Subject: Rezoning Petition Review

Rezoning Petition #: 22-017

Location of Property: Approximately 1.66 acres located on the south side of Mt. Holly-Huntersville Rd, west of Brookshire Blvd and east of Bellhaven Blvd.

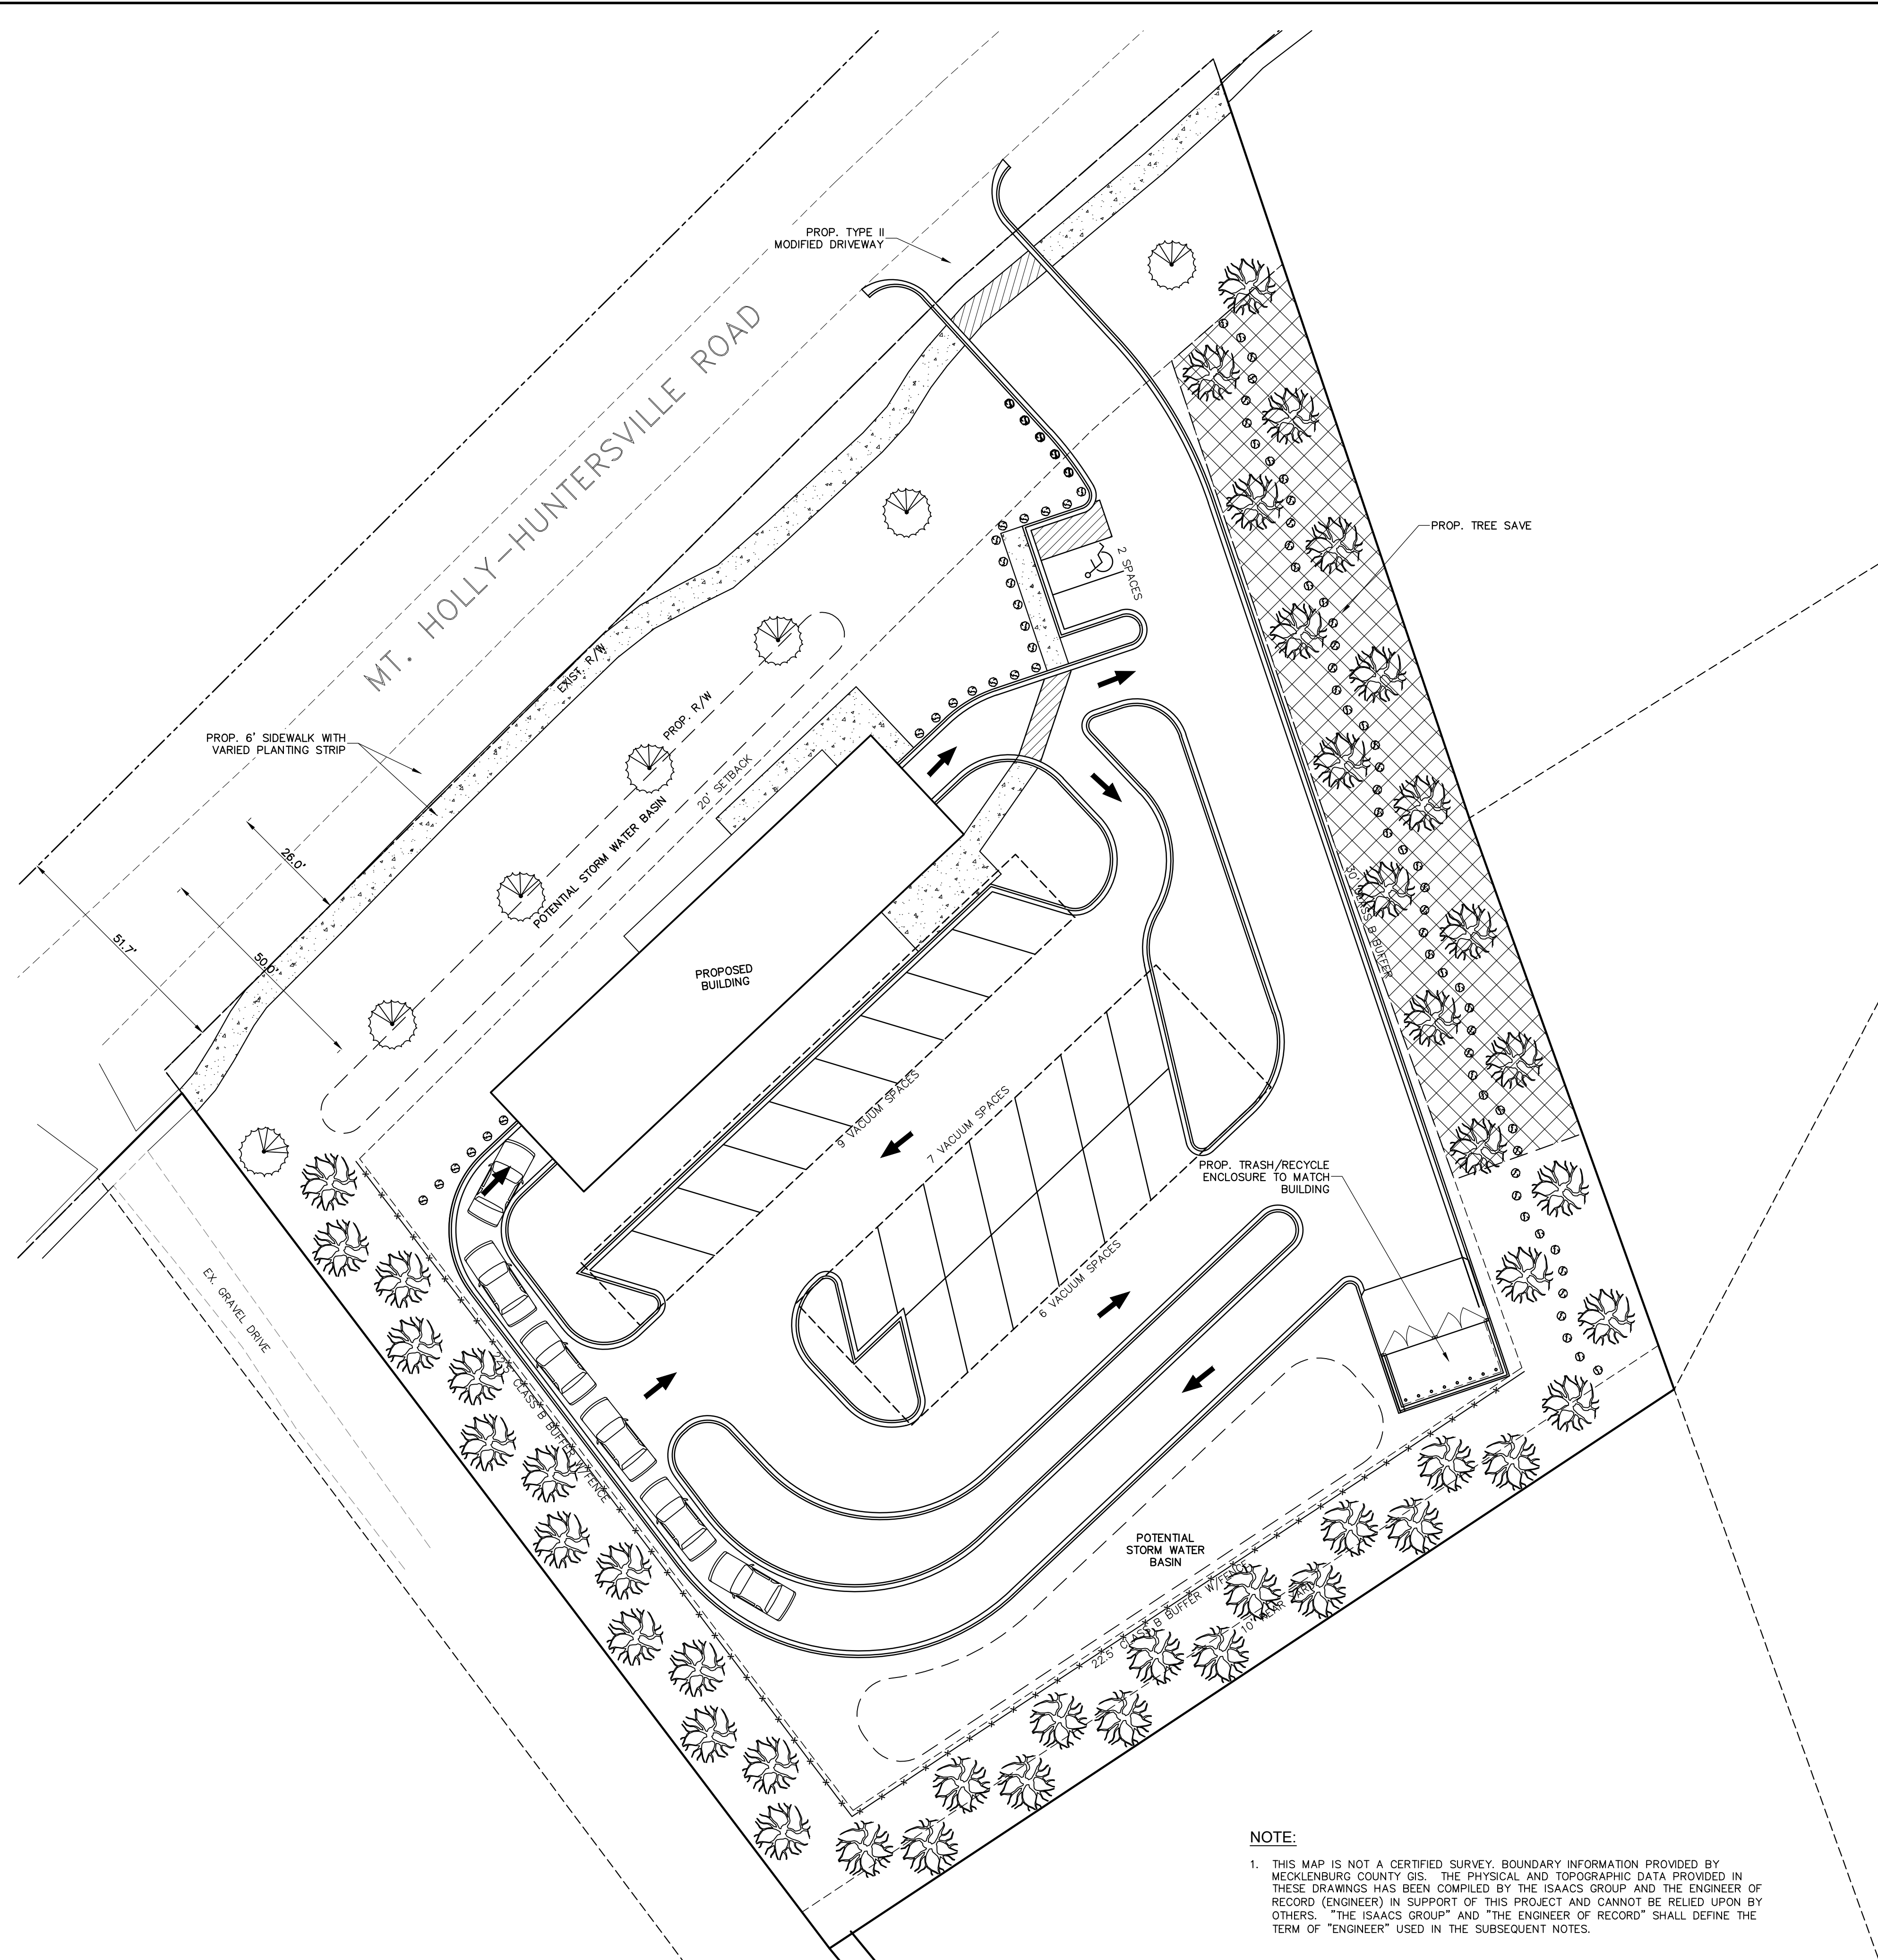
This property drains to Long Creek, which is an impaired/degraded stream, and may contribute to downstream flooding. This project has the opportunity to mitigate future impacts to this stream, therefore, Storm Water recommends placing the following notes on the plan:

For defined watersheds greater than 12% built-upon area (BUA), construct water quality stormwater control measures (SCMs) designed for the runoff generated from the first 1-inch of rainfall for all new and redeveloped BUA associated with the project. SCMs must be designed and constructed in accordance with the Charlotte-Mecklenburg BMP Design Manual.

For defined watersheds greater than 12% built-upon area, control the entire volume for the 1-year, 24-hour storm for all new and redeveloped BUA associated with the project. Runoff volume drawdown time shall be in accordance with the Charlotte-Mecklenburg BMP Design Manual.

For commercial projects with greater than 12% BUA, control the peak to not exceed the predevelopment runoff rates for the 10-yr, 6-hr storm and perform a downstream flood analysis to determine whether additional peak control is needed and if so, for what level of storm frequency, or if a downstream analysis is not performed, control the peak for the 10-yr and 25-yr, 6-hour storms.

For residential projects with greater than 12% BUA, control the peak to not exceed the predevelopment runoff rates for the 10-year and 25-year, 6-hour storms or perform a downstream analysis to determine whether peak control is needed, and if so, for what level of storm frequency.
